Our Reference: SYD18/01322/25

Departments Reference: SSD 9522

RESPONSE TO SUBMISSIONS ADDENDUM - KEMPS CREEK WAREHOUSE, LOGISTICS AND INDUSTRIAL FACILITIES HUB (SSD 9522)

Strategic Plan – Prepared by MU Group

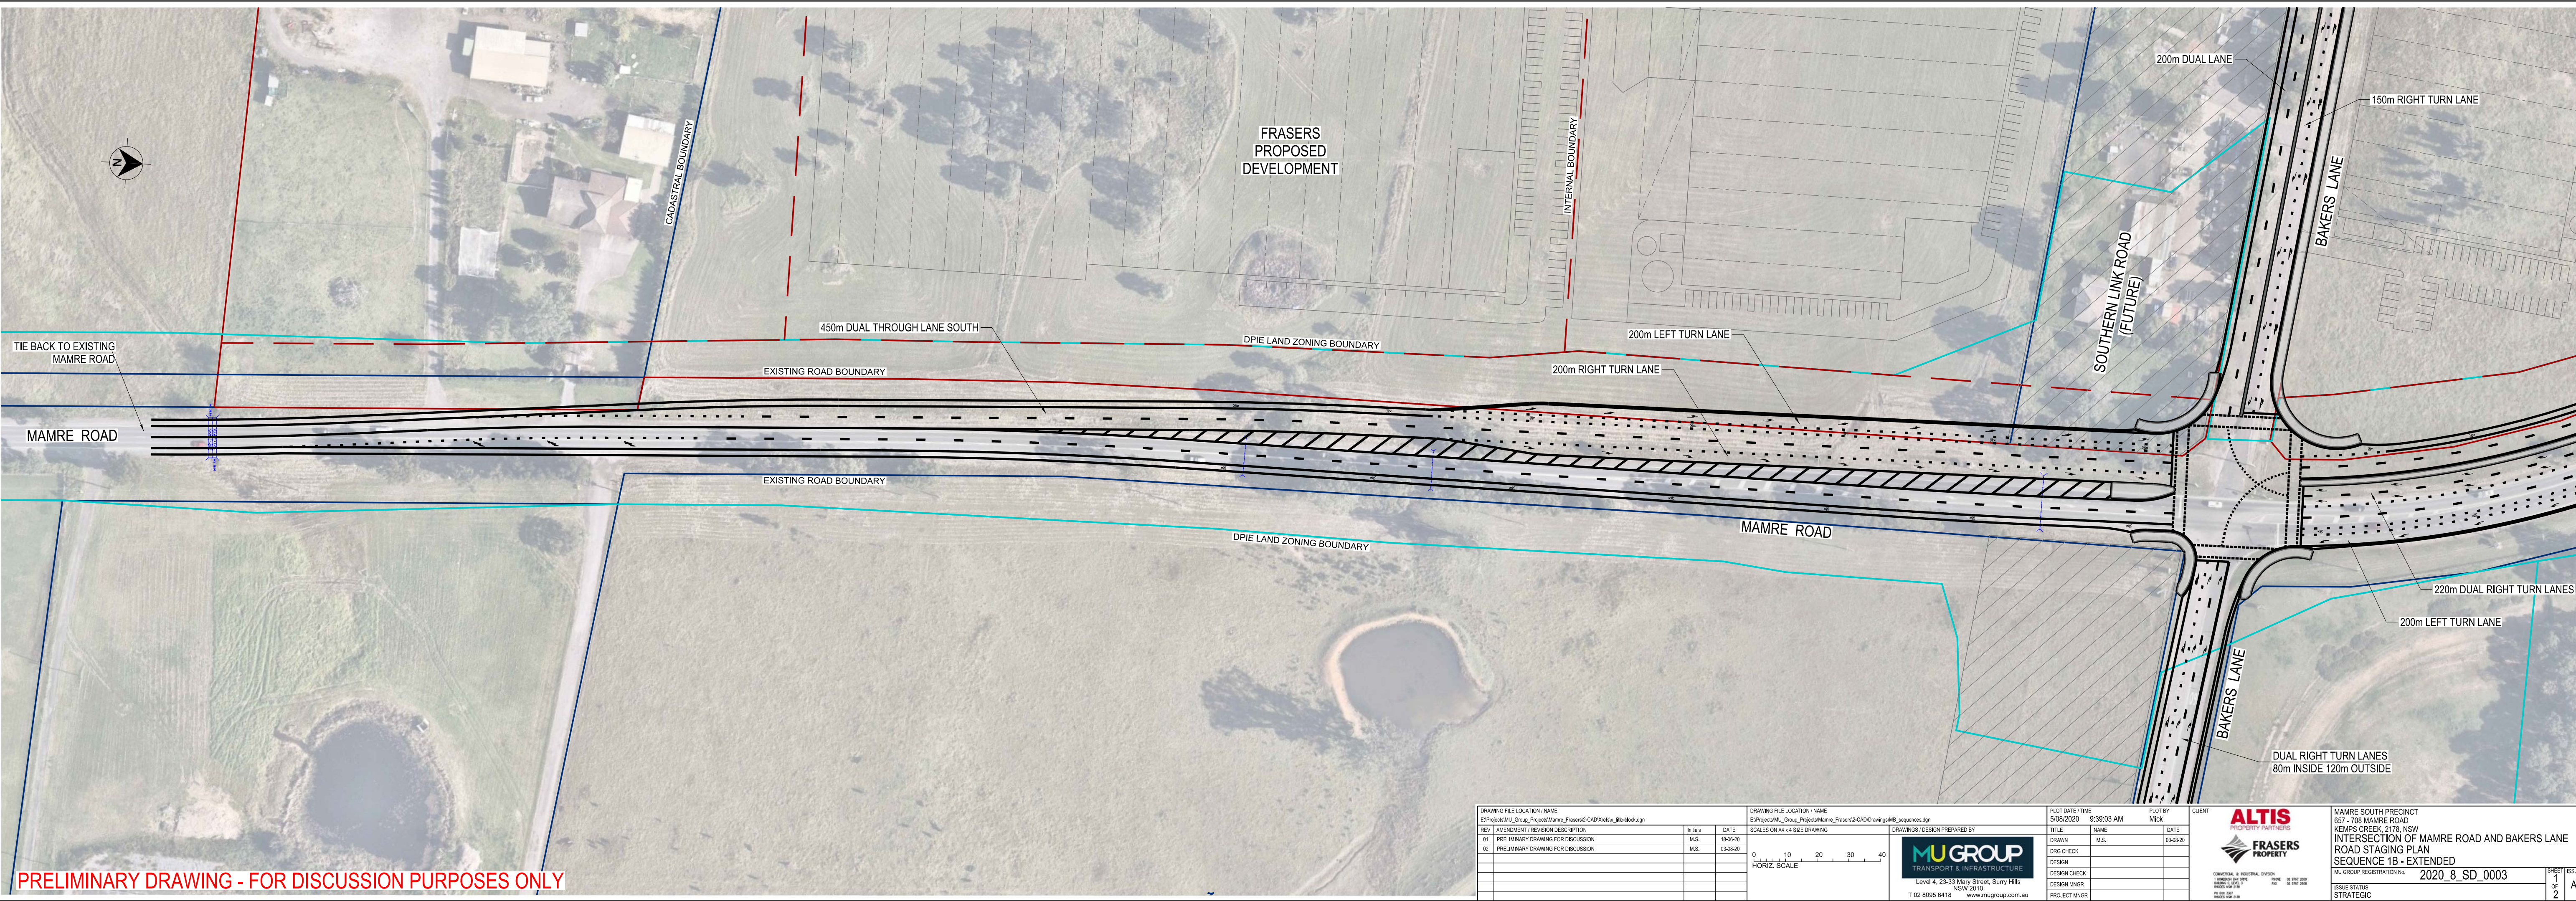
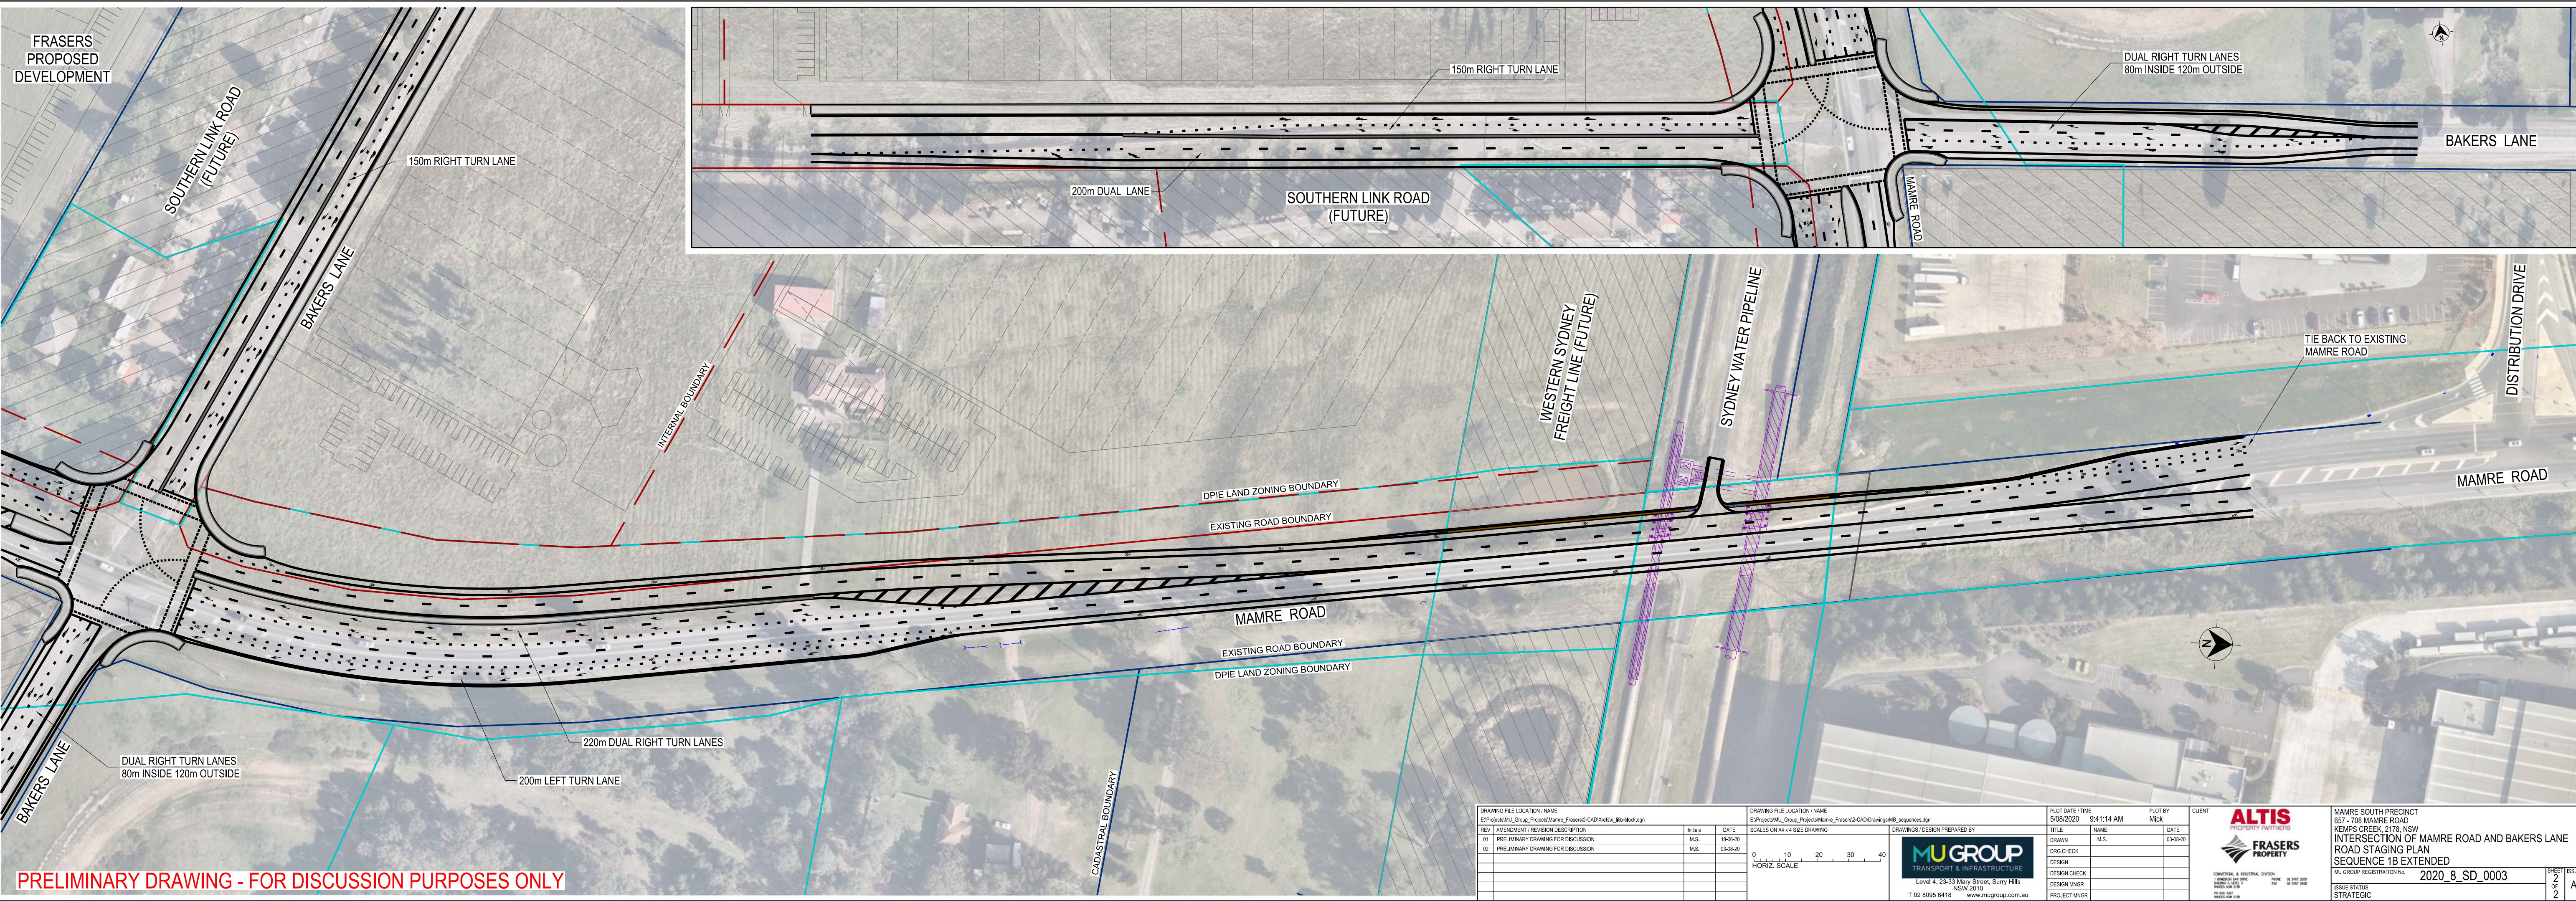
- The Strategic-Concept Design provided by *MU Group* supersedes the Sequence 1B as described in the latest Traffic Impact Assessment (TIA) by *AsonGroup* dated 03 August 2020;

- The proposed design by *MUGroup* does not align with the final Mamre Road upgrade and unlike the original design Sequence 1B which provided for a wider median consistent with the required Mamre Road corridor width. It is understood this is due to current land ownership constraints on the eastern side of Mamre Road;

1. The proposed Traffic Control Signal/s at the intersection of Mamre Road and Bakers Lane shall be designed to meet TfNSW requirements. The Traffic Control Signal (TCS) plans shall be drawn by a suitably qualified person and endorsed by a suitably qualified practitioner.

The submitted design shall be in accordance with Austroads Guide to Road Design in association with relevant TfNSW supplements (available on www.rms.nsw.gov.au). The certified copies of the TCS design and civil design plans shall be submitted to TfNSW for consideration and approval prior to the release of a Construction Certificate and commencement of road works. Please send all documentation to development.sydney@rms.nsw.gov.au.
